Memorandum

Subject: Montage Units Traffic Impact Analysis and Montage Units Charter School Neighborhood Impact Assessment (NIA) Memo Review Response

Date: August 25, 2021

Site Plan

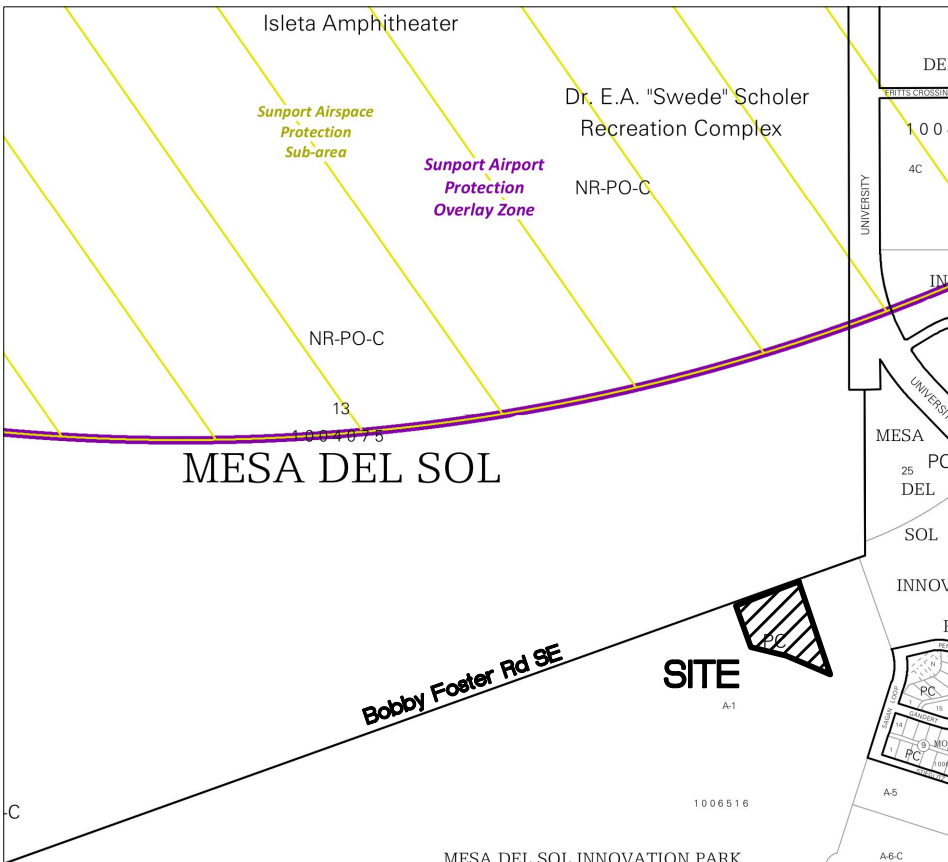
7. Drop-off queuing is blocking Stieglitz Ave. and the on-street parking on Stieglitz Ave. Stieglitz Ave. is 12 feet wide one-way and will not permit vehicle to pass by the queued vehicles. This will not be approved as presented. Provide solutions to minimize disruption of normal traffic during pick-up and drop-off of students.

The queue from Scenario 1 is not the expected queue. This was presented as an extreme scenario. If recommendations provided in Section 6.1 are followed, the expected queue is expected to be similar to Scenarios 2 and 3. Wrote this into the NIA Section 5.1.

Figure 1 - Study Area

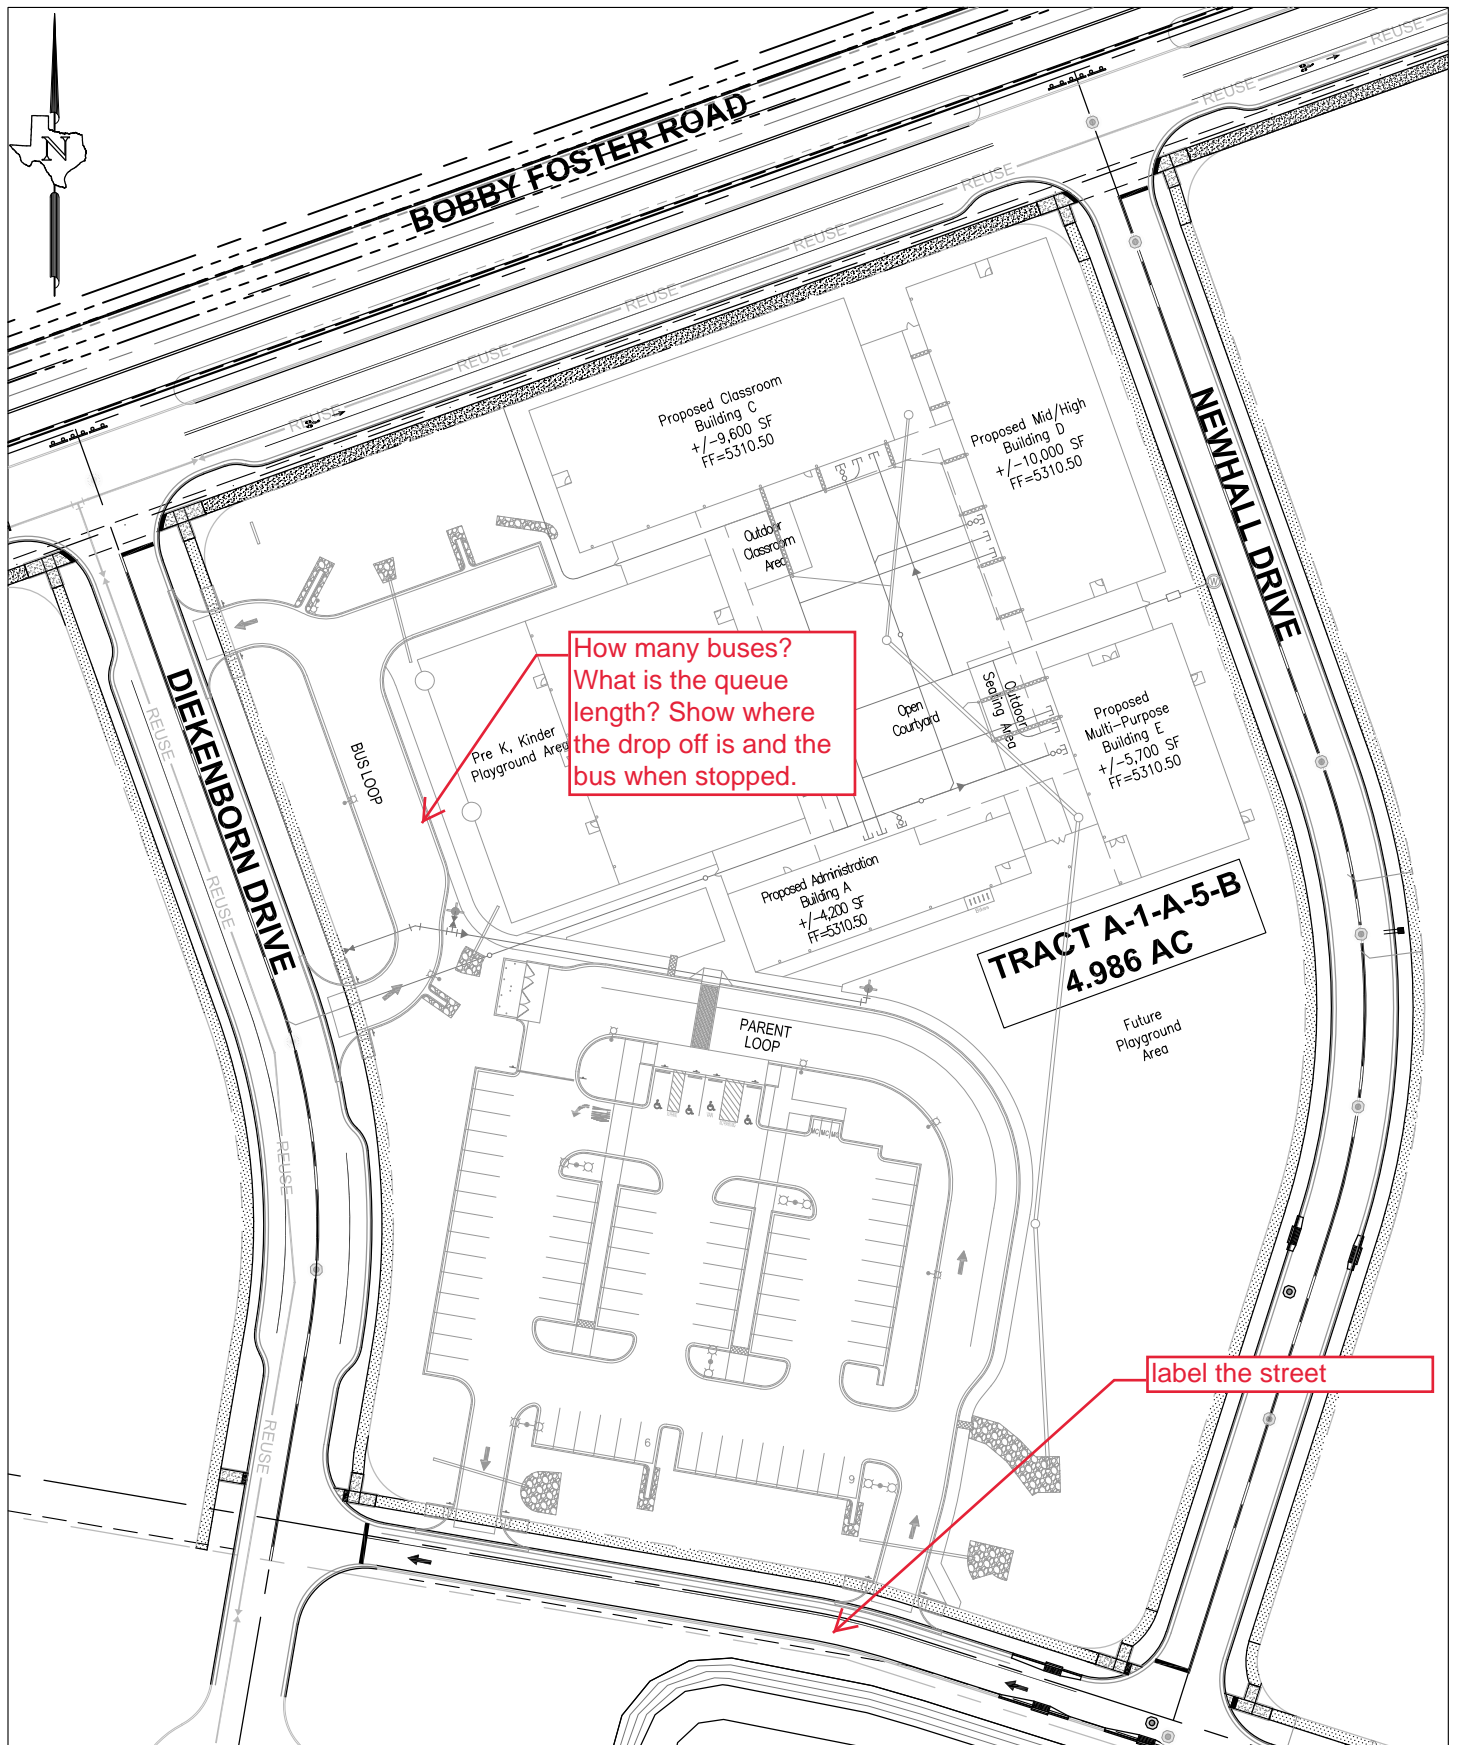
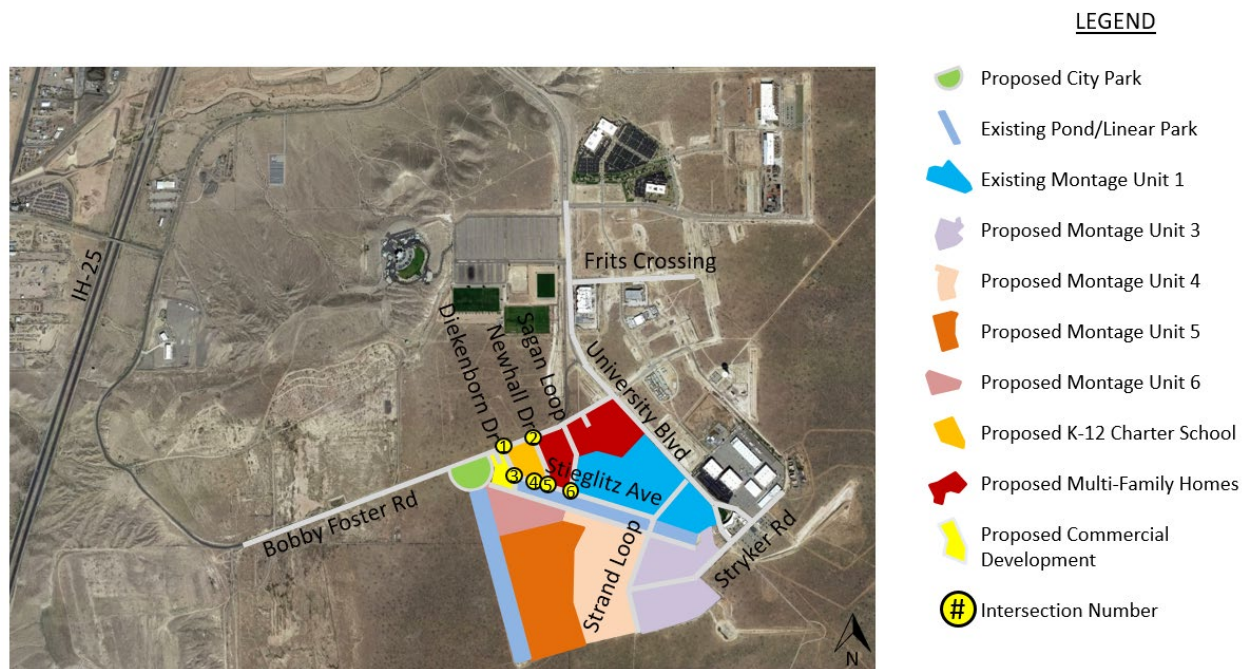
2. Site Location/study Area: Provide intersection diagrams for the proposed intersections. This will act as a crosscheck for the written description while improving the ease of understanding what is proposed.

Included figure. (Figure 2)
